Boston Alternative Energy Facility

Appendix E2 to Natural England's Deadline 2 Submission

**Further Natural England Advice in Relation to the Alignment of the England Coast
Path (ECP)**

Planning Inspectorate Reference: EN010095

TITLE
 BOSTON ALTERNATIVE ENERGY FACILITY
 DEVELOPMENT CONSENT ORDER
 Regulation 5(2)(k) - Access and Rights of Way Plan
 BOSTON BOROUGH COUNCIL
 Sheet 1 of 1

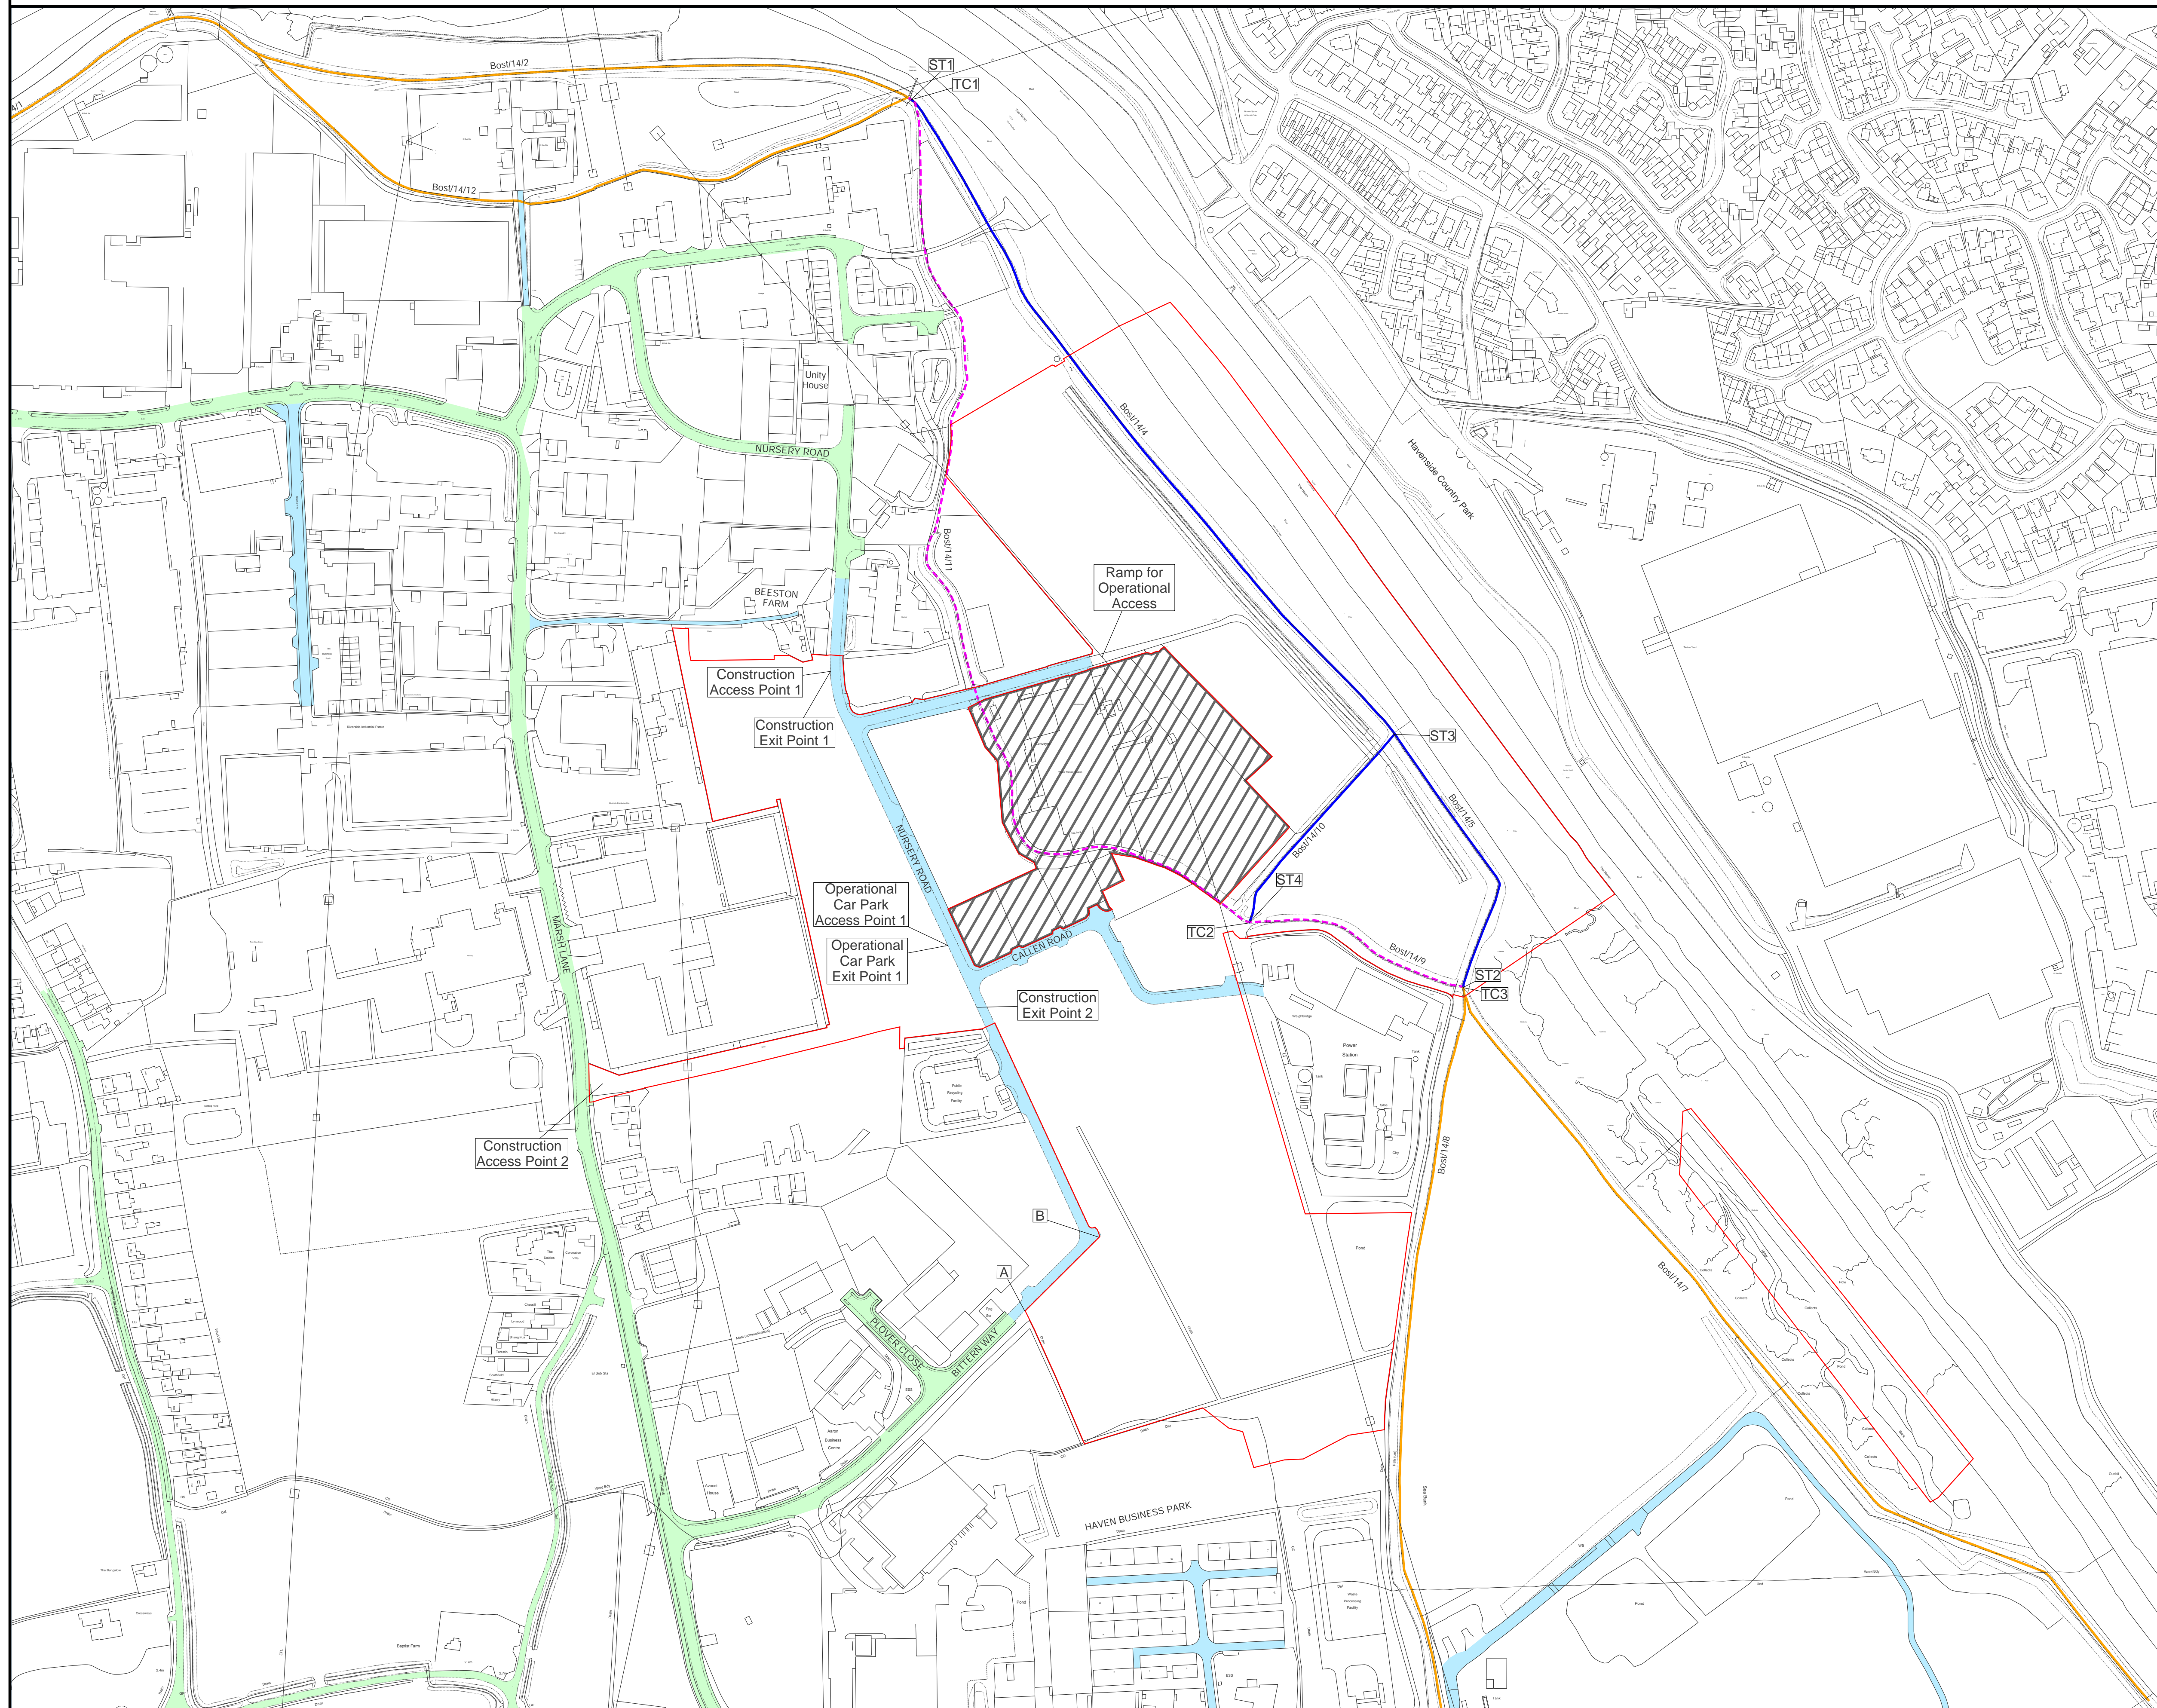
Contrary to Section 5.3.29 of the Environmental Statement, **Natural England doesn't support the Applicant's proposed new alignment of the ECP**. Natural England advise that the proposed new alignment unnecessarily constrains access to the coast which is contrary to the ECP legislation as designated by parliament.

In order to satisfy the legislative requirements for the national trail, Natural England advises that the Applicant must provide further evidence to justify the proposals to significantly extinguish part of the current ECP route. Especially, when under the Marine and Coastal Access Act 2009 (Part 9) there are powers, and therefore options, to create new routes that better fit the legal expectations of the ECP than simply diverting to existing Public Rights of Way (PRoW).

Natural England therefore advises that alternative options such as that proposed in **Figure 1** below should be fully explored and assessed by the Applicant.
